From: Patel, Uday [Uday.Patel@lancashire.gov.uk]
Sent: 23 July 2013 10:13
To: planning
Cc: ENV LHS Customer Service
Subject: 3/2013/0339 - Unit 2 Hall Street Clitheroe Lancashire BB7 1HJ - Proposed change of use of an existing industrial unit to a sports injury clinic

Planning Application Reference: 3/2013/0339

Location: Unit 2 Hall Street Clitheroe Lancashire BB7 1HJ

Proposal: Proposed change of use of an existing industrial unit to a sports injury clinic

PROPOSED INTERNAL
LAYOUT AND PARKING

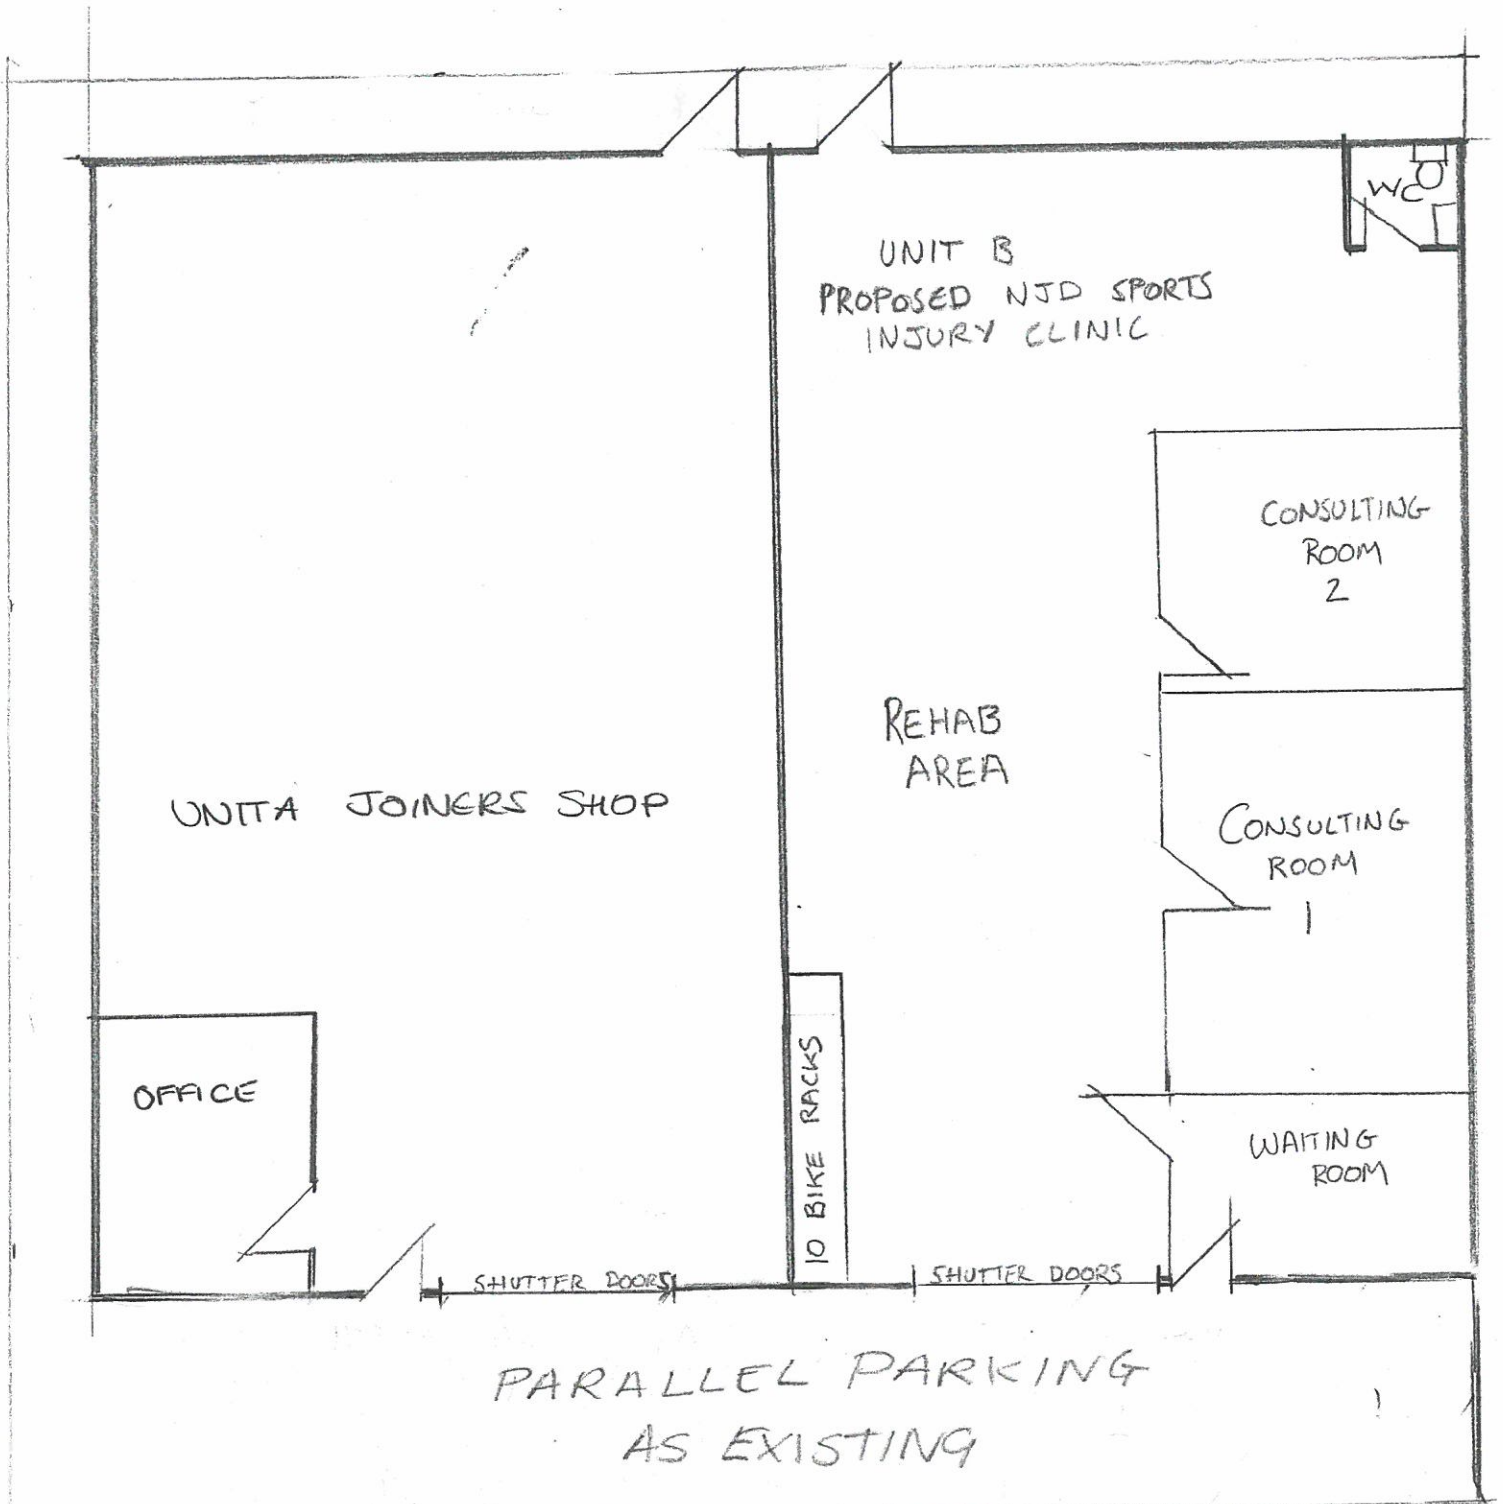
Proposed development suggest to have 2 consulting rooms and customer sitting area within the premises. According to JLSP parking standard guidelines, D1 type use will require 4no parking spaces for each consulting room. Thus there will be 8no parking spaces required for the proposed development. With regard to the proximity of the property to the town centre location the accessibility score for the proposed location is approximately 21 which is considered as medium accessibility score for the proposed location. Thus applying approximately 12% parking reductions, the required parking will be 7nos. Thus there is increased parking demand for the proposed development.

It is noticed that there are two accesses to the property. One the main roller shutter access and another a pedestrian access to the sitting area. It is realised that it may not be practical to park the vehicle in front of the pedestrian access and vehicular access to the property. This situation will leave almost no parking available for customers and staff to park their vehicles.

It is also realised that the customers visiting the clinic are likely to come slightly early then the appointment time. Considering multi consulting rooms in use, there may be possibility of more than one patient along with some visitor coming to the clinic. It is noticed that there are several number of bicycle storage spaces available in the premises which is encouraging the staff and others to use environment friendly way of transport. However it is anticipated that most of the patients are likely to visit the clinic by car or other such vehicle including use of emergency service vehicles.

Considering the above matter, it is believed that the proposed development is not a betterment to the highway in terms of parking. The proposed layout of the development does not suggest accommodation increased demand of parking. It is anticipated that proposed development is likely to affect the adjacent highway and in particularly the vicinity of the residential development around.

In view of the above, there is an objection to the proposed development on highway grounds.
